**OS Parcel 5700 South West Of Grange Farm,  
Street Through Little Chesterton, Chesterton**

**23/02810/NMA**

**Proposal:** Amendments to the wording of condition 2 (proposed as non-material amendment to 22/01144/F)

Drawing Name:
ENHANCED - Phase 1 - Elevations

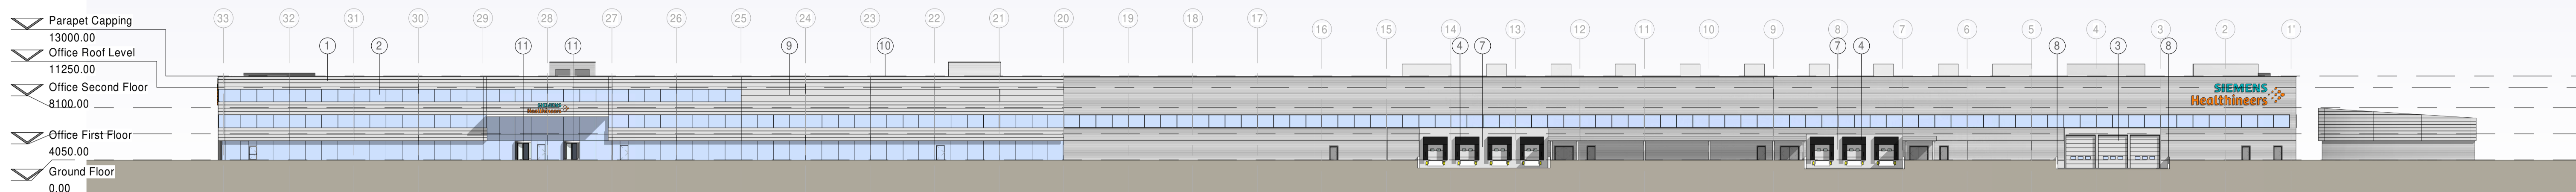
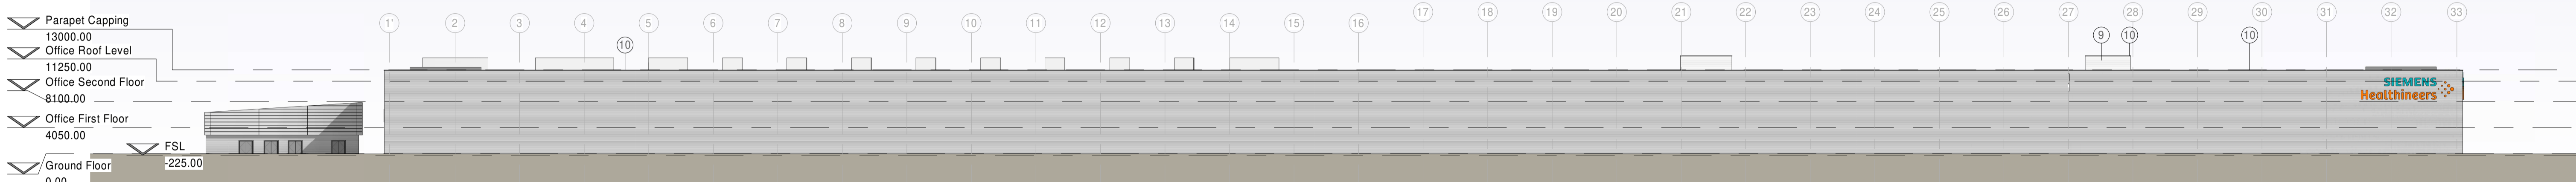
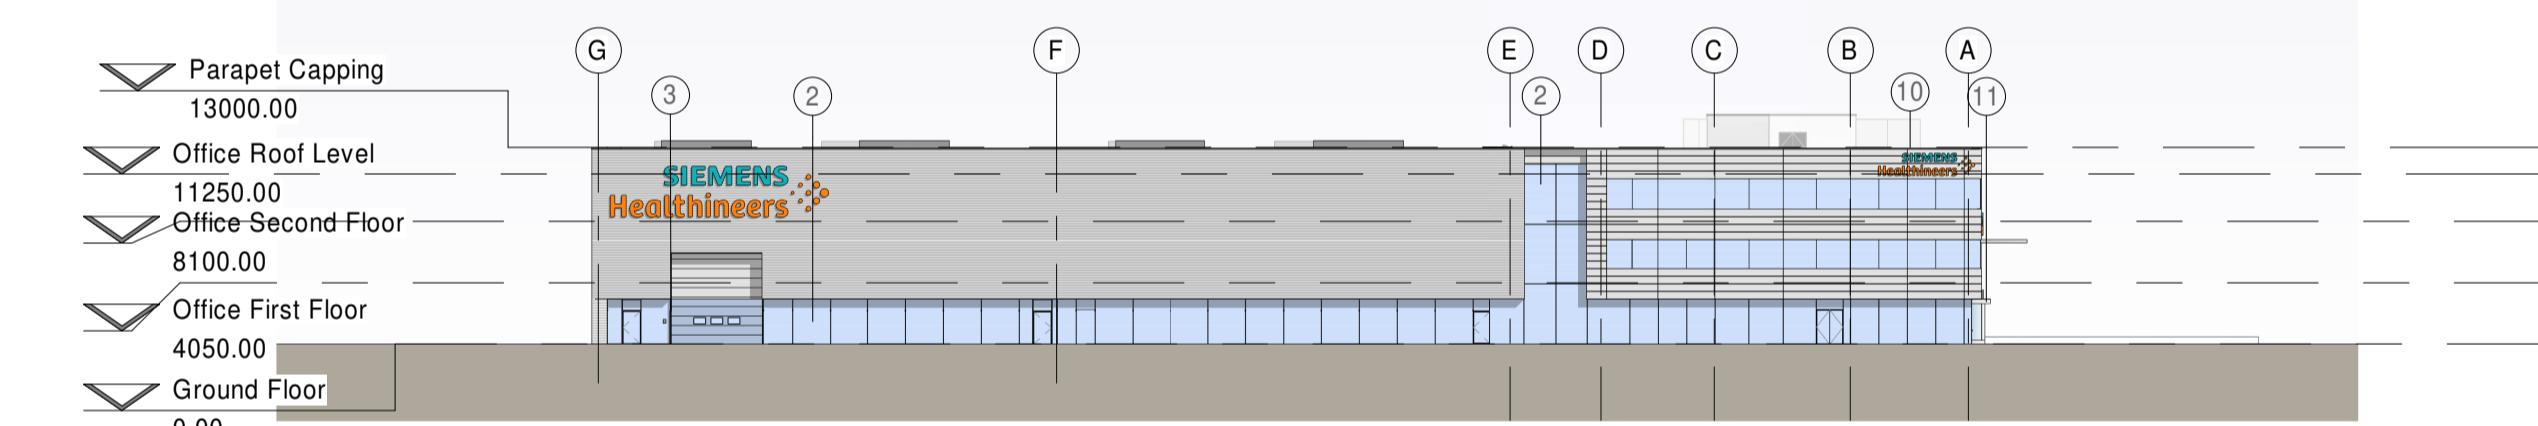
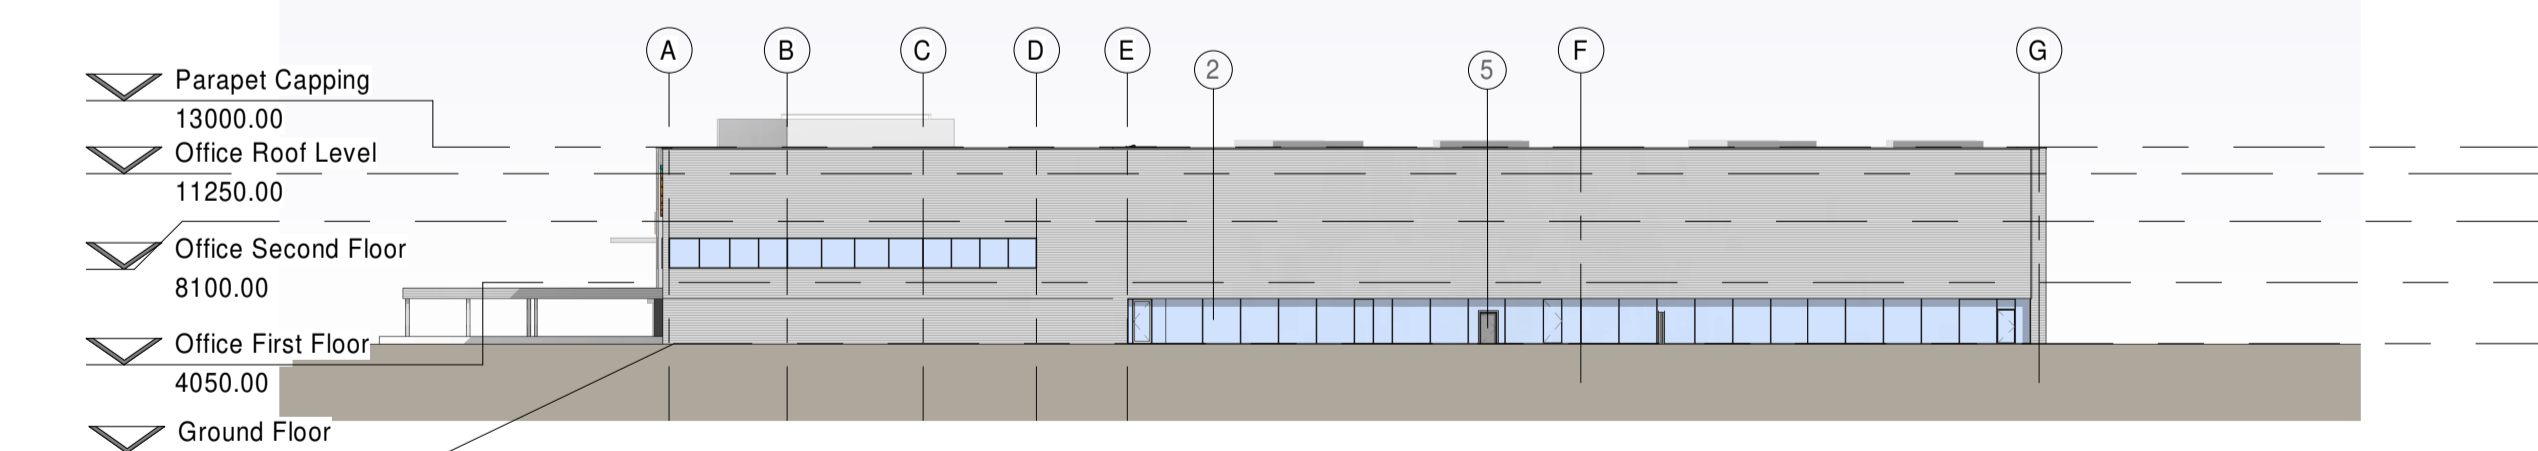
- Minor changes to the elevational details including:
  - NE Elevation: Replace built-up system with composite cladding panels; glazed windows added to second floor offices and Goods In office, relocation of 1 x revolving door and repositioning of doors/addition of roller doors;

- SW Elevation: 6 x external, personnel doors added;
  - SE Elevation: Repositioning of doors and addition of double doors;
  - NW Elevation: Repositioning of doors and addition of double doors.

Drawing Name: Roof Plan

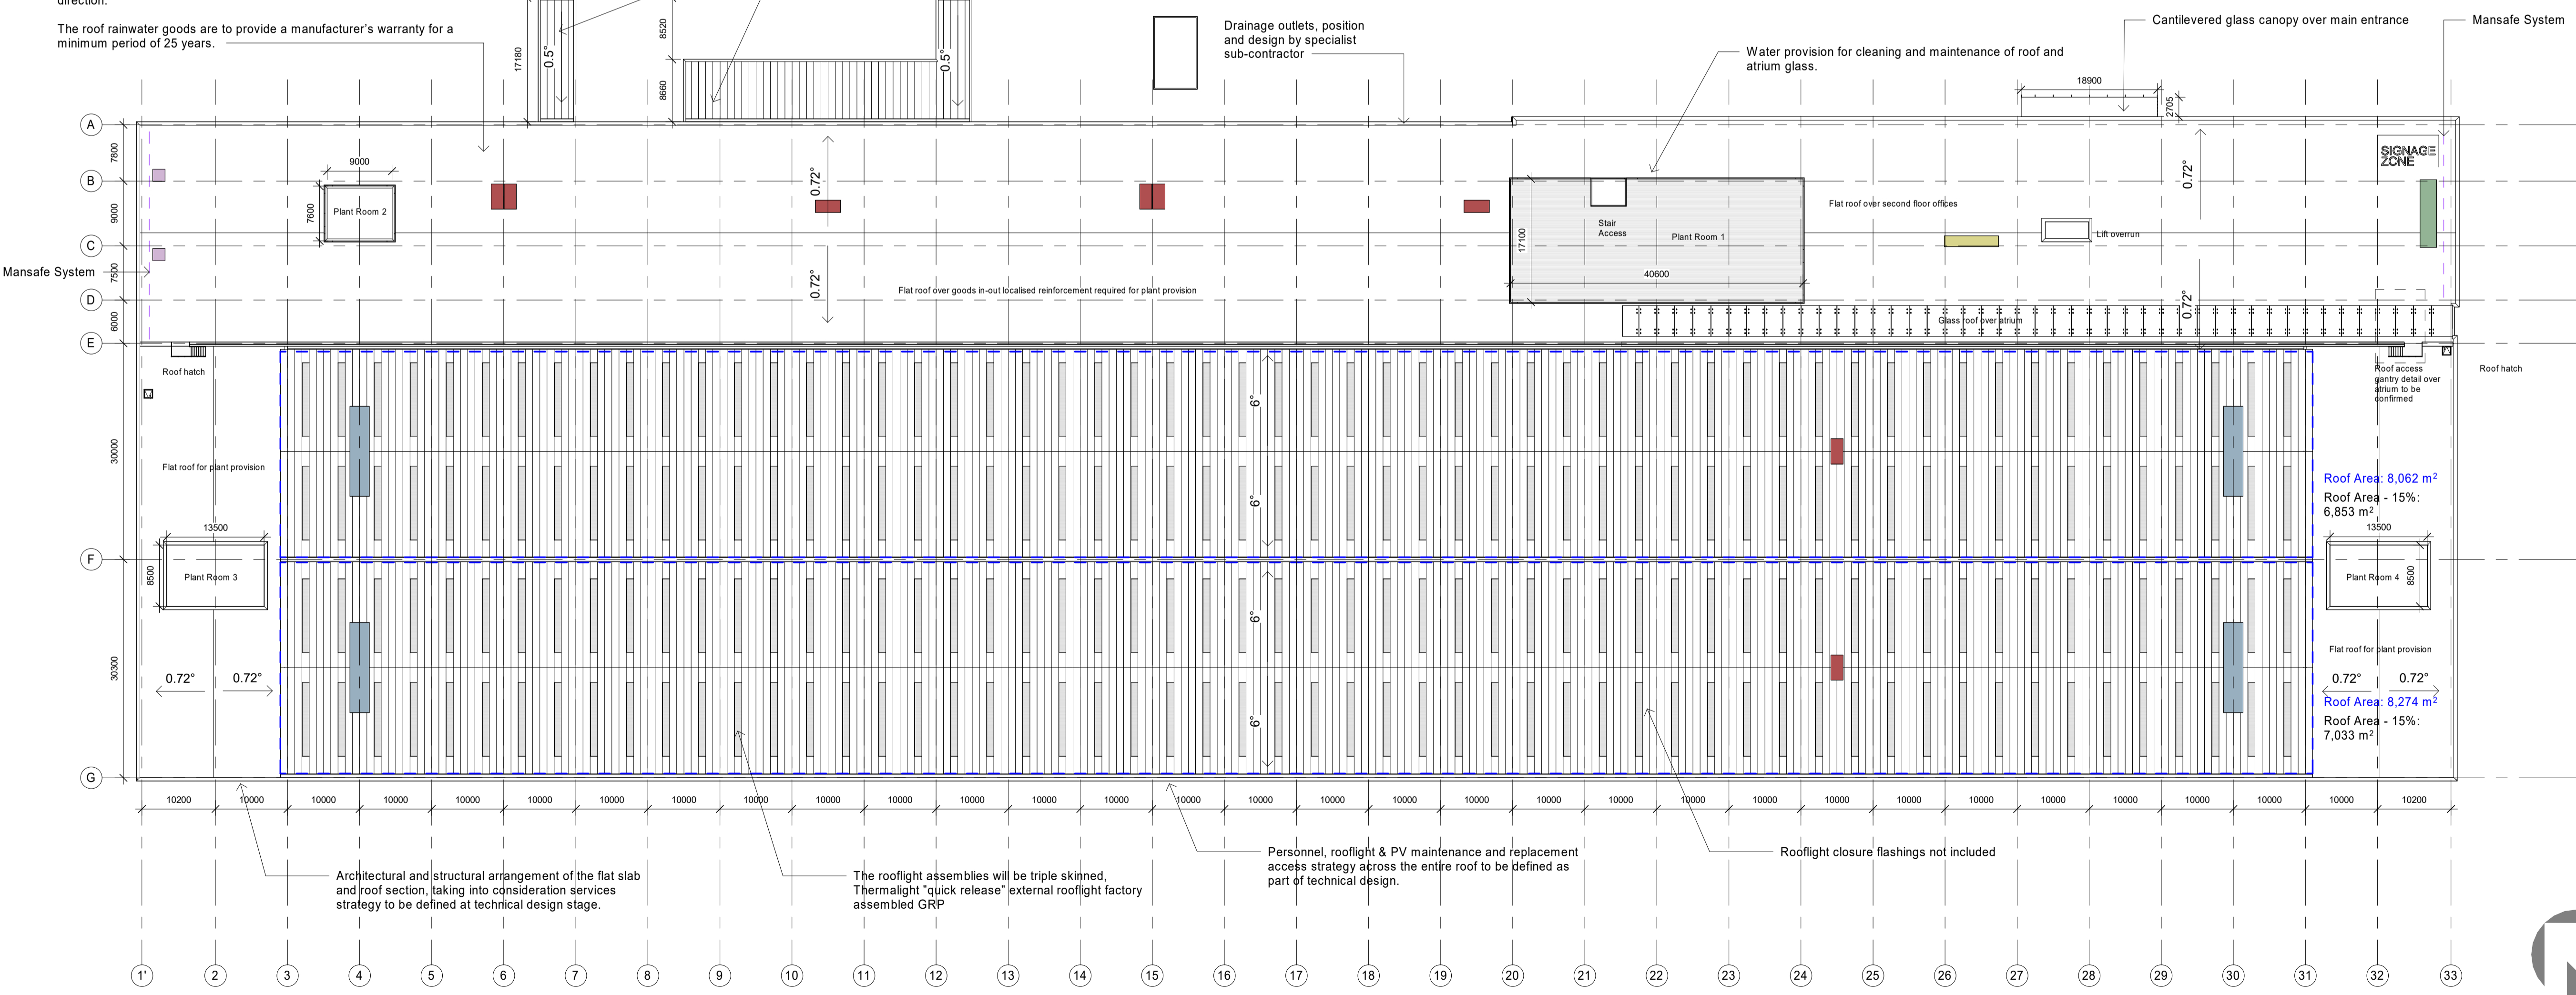
- Rationalisation of services/plant equipment on the roof. Where these protrude from the roof, they will be visually enclosed in a reduced number of plant rooms and service kennels to rationalise operational requirements and minimise visual clutter. The maximum height of the plant rooms does not exceed the maximum height of the 16.15m fall protection railing currently approved. There is however a lift overrun measuring 3.9m x 4.9m in size which would protrude from the roof at an overall height of 17.40m; 1250mm higher than the highest part of the approved roof.

- 5.6. The changes to the plant rooms and housings on the roof would mean that visual clutter is reduced. Whilst some of the structures would be higher than approved, all but one (lift housing) would remain below the height of the approved fall protection railing. Taking account of the size and appearance of the consented building it is not considered that the changes to the roof plant/service structures would be significant or detrimental to the character and appearance of the building or the surrounding area.
